**RE: 6-16 ATCHISON STREET, ST LEONARDS
PART 3A DEVELOPMENT
DEPARTMENT OF PLANNING REFERENCE: MP 09_0187**

REPORT TO THE GENERAL MANAGER

ADDRESS/WARD:	6-16 Atchison Street, St Leonards (W)
APPLICATION No:	PART 3A DEVELOPMENT Department of Planning Reference: MP 09_0187; Amended Proposal.
PROPOSAL:	Amended Proposal and Preferred Project Report for demolition of existing buildings / structures, excavation and construction of a 28 storey mixed use building with 76 hotel suites, gymnasium, café/ restaurant, 173 apartments, with basement for 168 cars, through site link and public domain works.
PLANS REF:	Drawings numbered PA-100-01 to PA-100-17 (inclusive), PA-200-01 and 02, PA-210-01 to PA-210-07 (inclusive), and PA-300-01 to PA-300-04 (inclusive), dated April 2011, drawn by Francis Jones Morehen Thorp Pty Ltd, and Stormwater Drainage Concept Plans numbered H 100 to H 117(inclusive), Issue 01, dated March 2010 drawn by Warren Smith and Partners Pty Ltd.
OWNERS:	Everex Investments P/L
APPLICANT:	City Plan Services, on behalf of Bancor Developments Pty Ltd

**Basement Loading Dock B1**

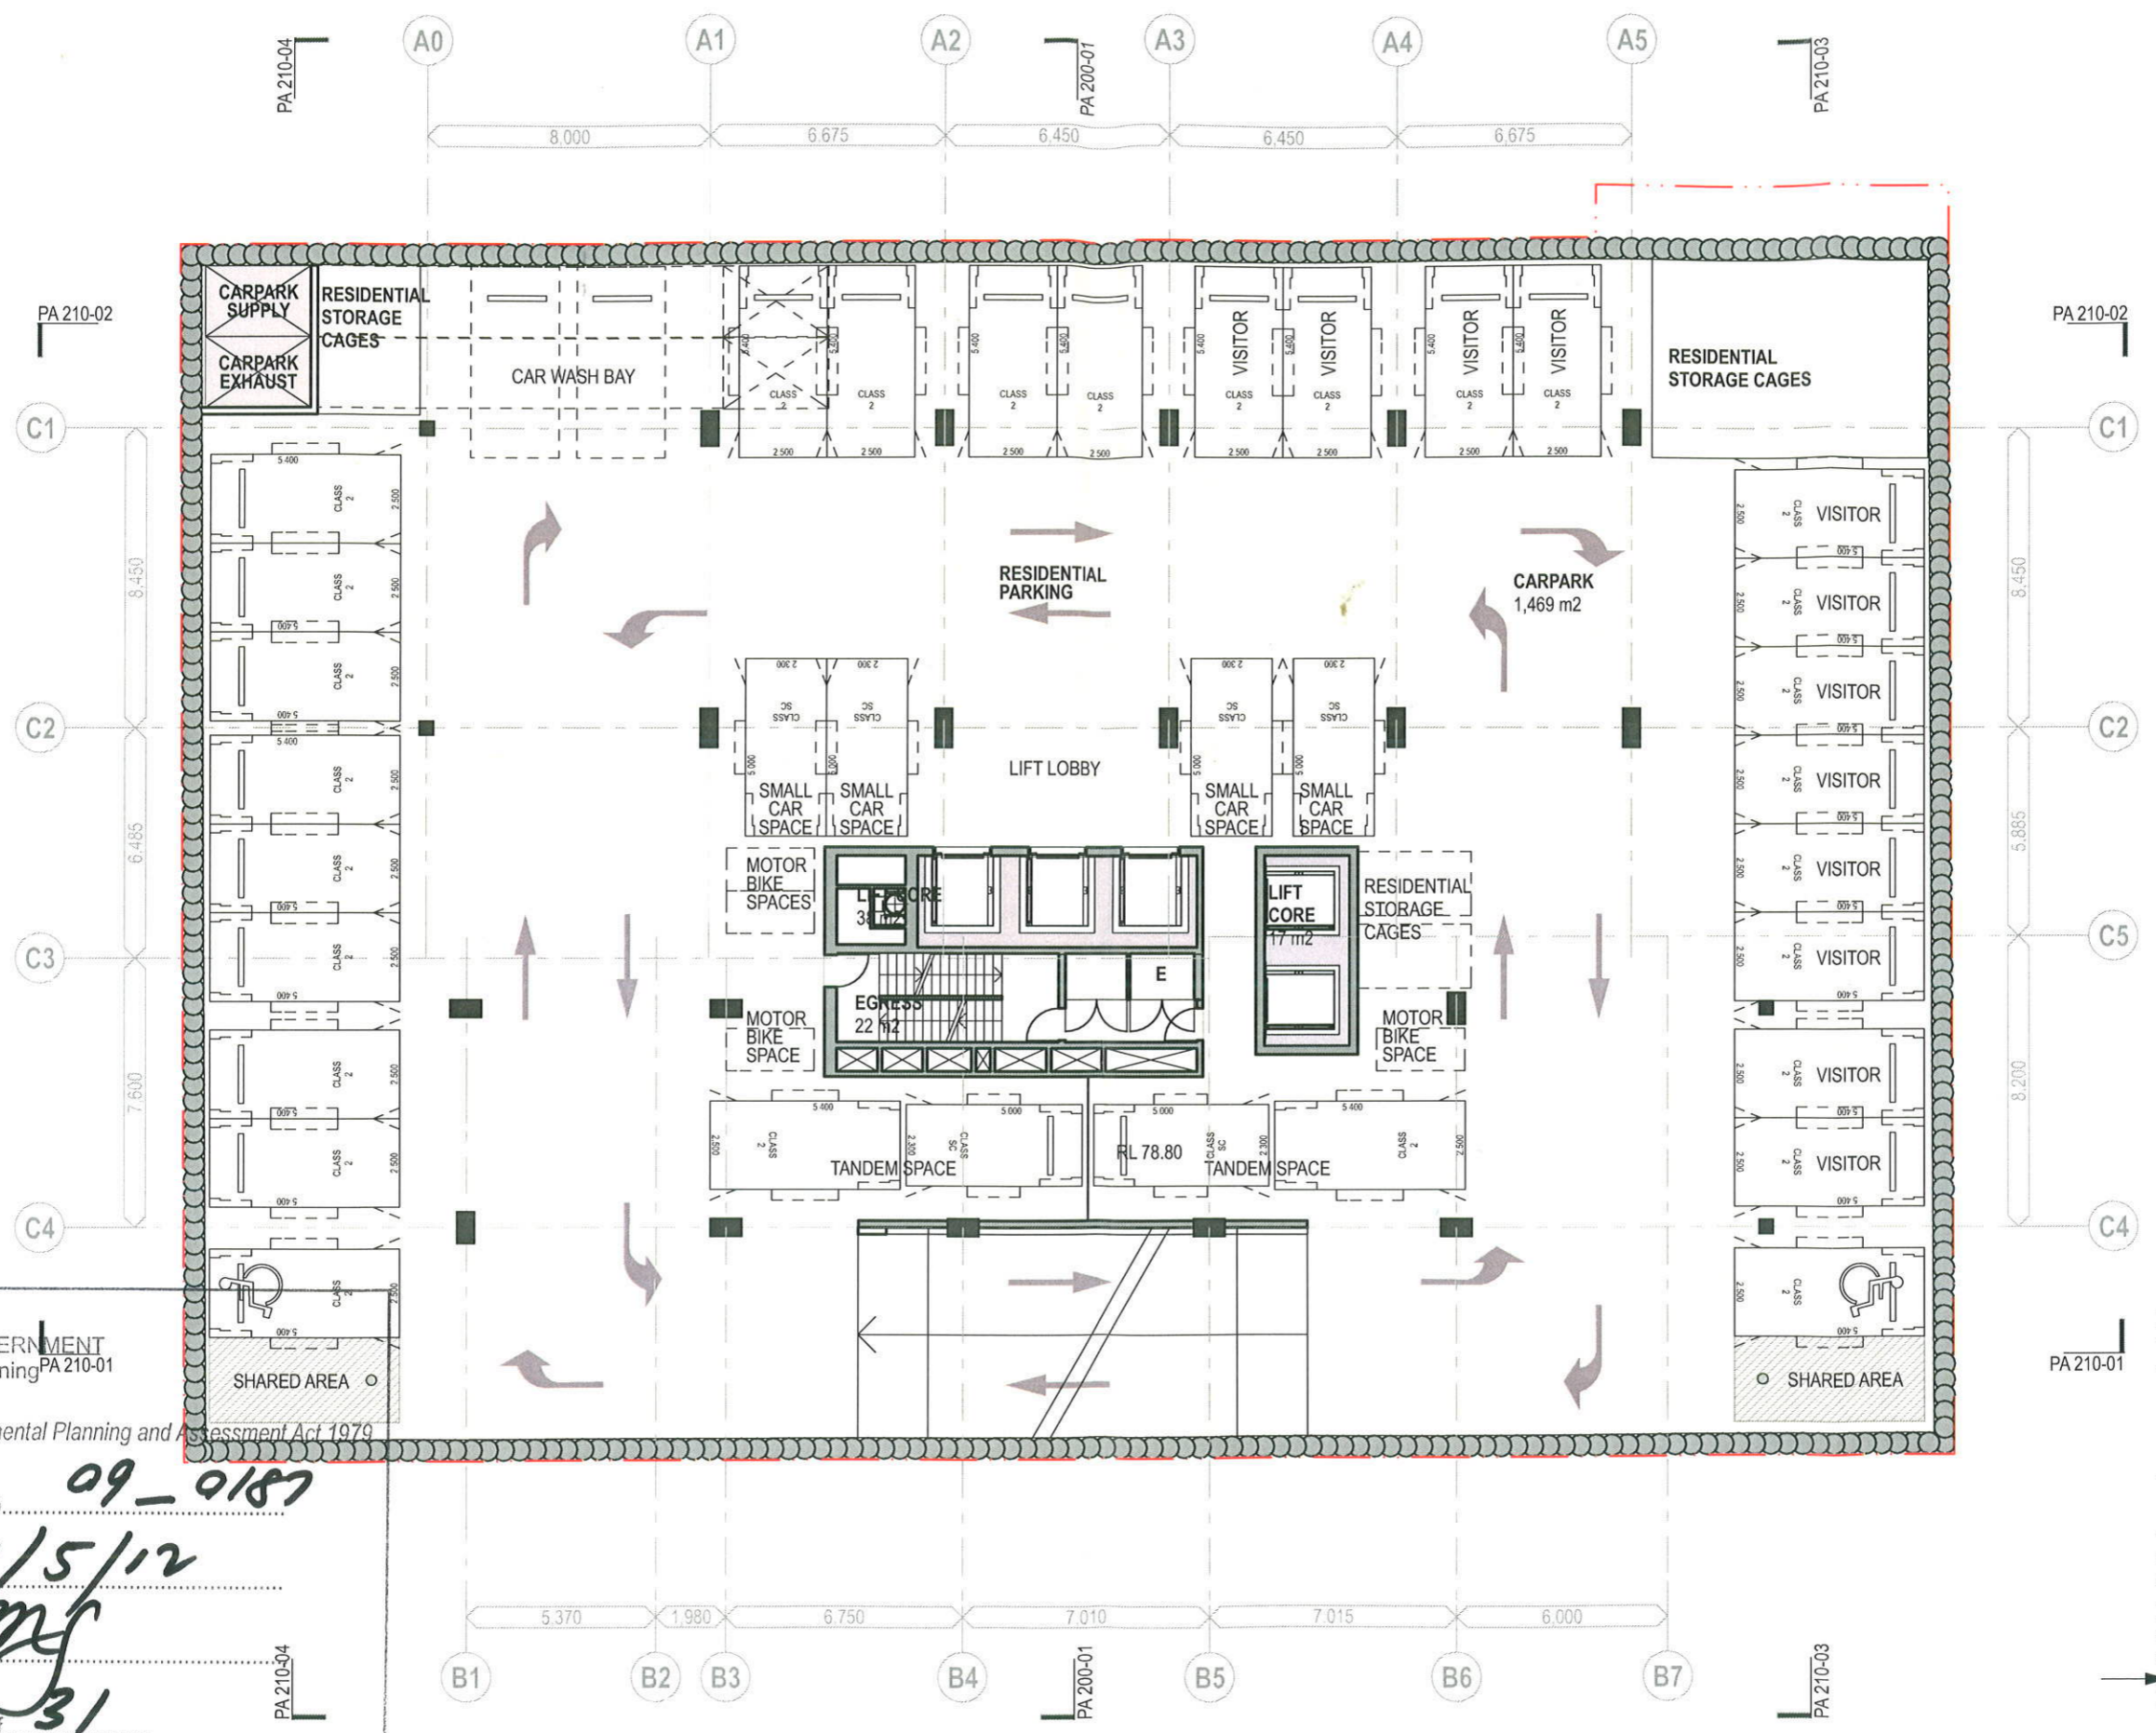
The design of the proposed loading dock and access driveway / turning area remains unchanged compared to the original proposal. The proposed single loading dock is sized to cater only for a small rigid vehicle (6.6m long x 4.0m wide). This is considered inadequate for a development of this size.

- D. **THAT** the loading dock caters for a maximum size removal vehicle for a development of this size.
